CITY OF ALBUQUERQUE

March 28, 2025

Re: Retail Shell Bldg
845 Juan Tabo Blvd NE
30-Day Temporary Certificate of Occupancy
Transportation Development Final Inspection
Architect's Stamp dated 09-20-24 (K21-D019A)
Certification dated 03-25-2025

7 BICYCLE RACK
SCALE: 3/4"=1'-0"

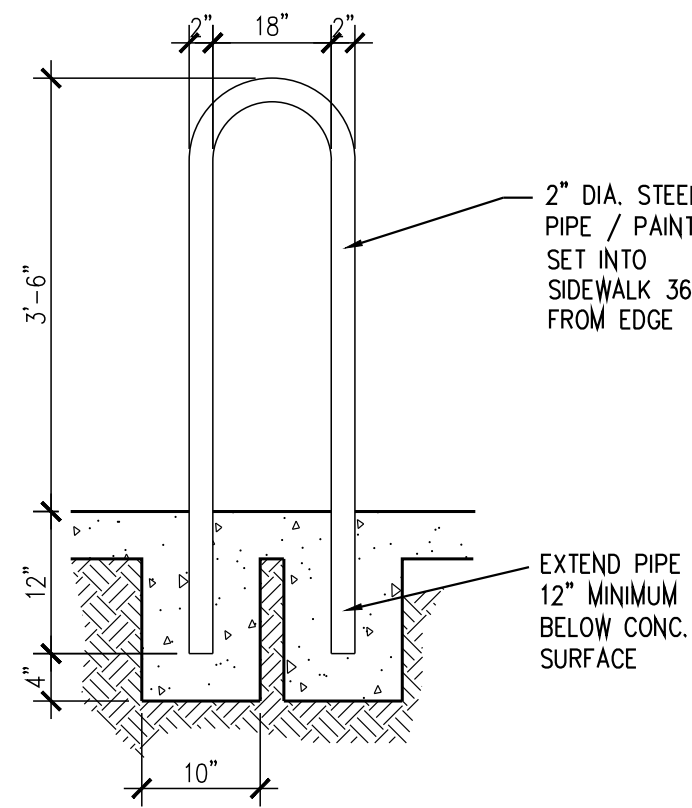
- Per approved site plan and city requirement, please install the "U" shape Bike rack following the required dimensions.
